Address: 319A, Halifax Road, Liversedge, WF15 6NE

Application number: 2026/90765	
What is the application for?:	Erection of two storey side extension and detached garage with associated altera
Address of the site or building:	321, Halifax Road, Hightown, Liversedge, WF15 6NE
Postcode:	WF15 6NE

**DRAWING TITLE**  
Site Location Plan and Proposed Site Plan

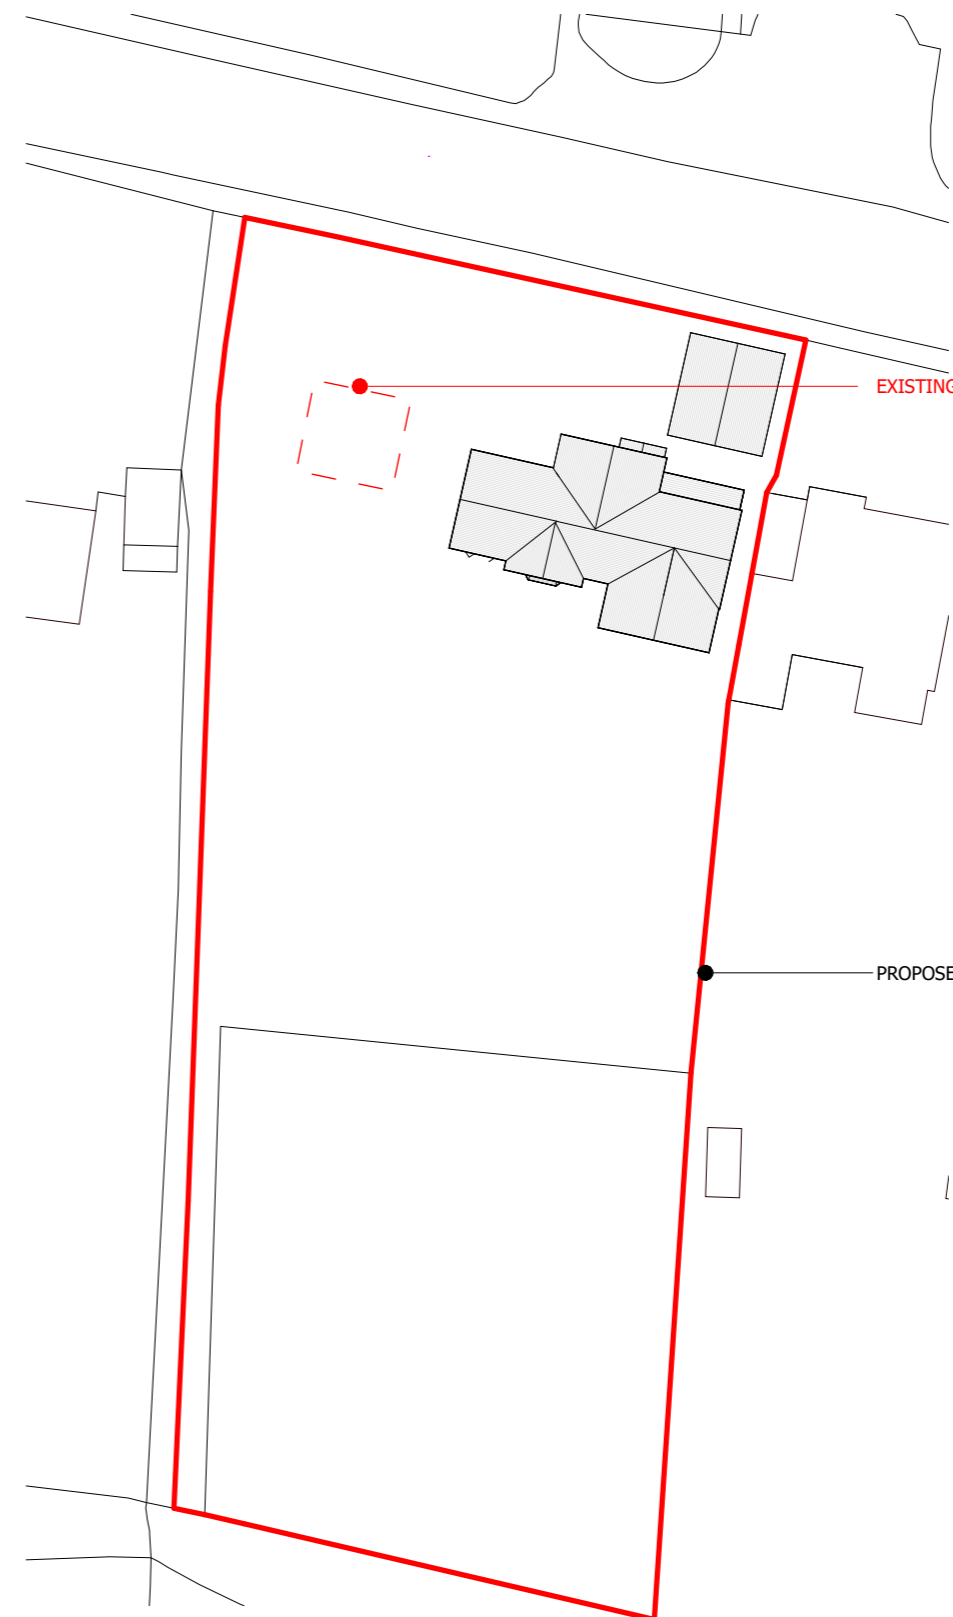
3. The proposed garage re-positioning - the applicant has provided no evidence or justification for the position of the replacement garage in front of the building line. Kirklees Supplementary Planning Document "House Extensions and Alterations" states, at paragraph 5.30, that outbuildings such as garages should "normally" be set back behind the building line of the original building so that they do not impact on the street scene. Clearly, the location of the proposed garage between the front elevation of the original building and the highway will have a considerable impact on the character and appearance of the area, and will only serve to further undermine the green belt in this location. No justification has been put forward as to why the garage needs to be in this location. The height of the garage, so close to the extension/boundary, will have a negative impact on 319A Halifax Road.
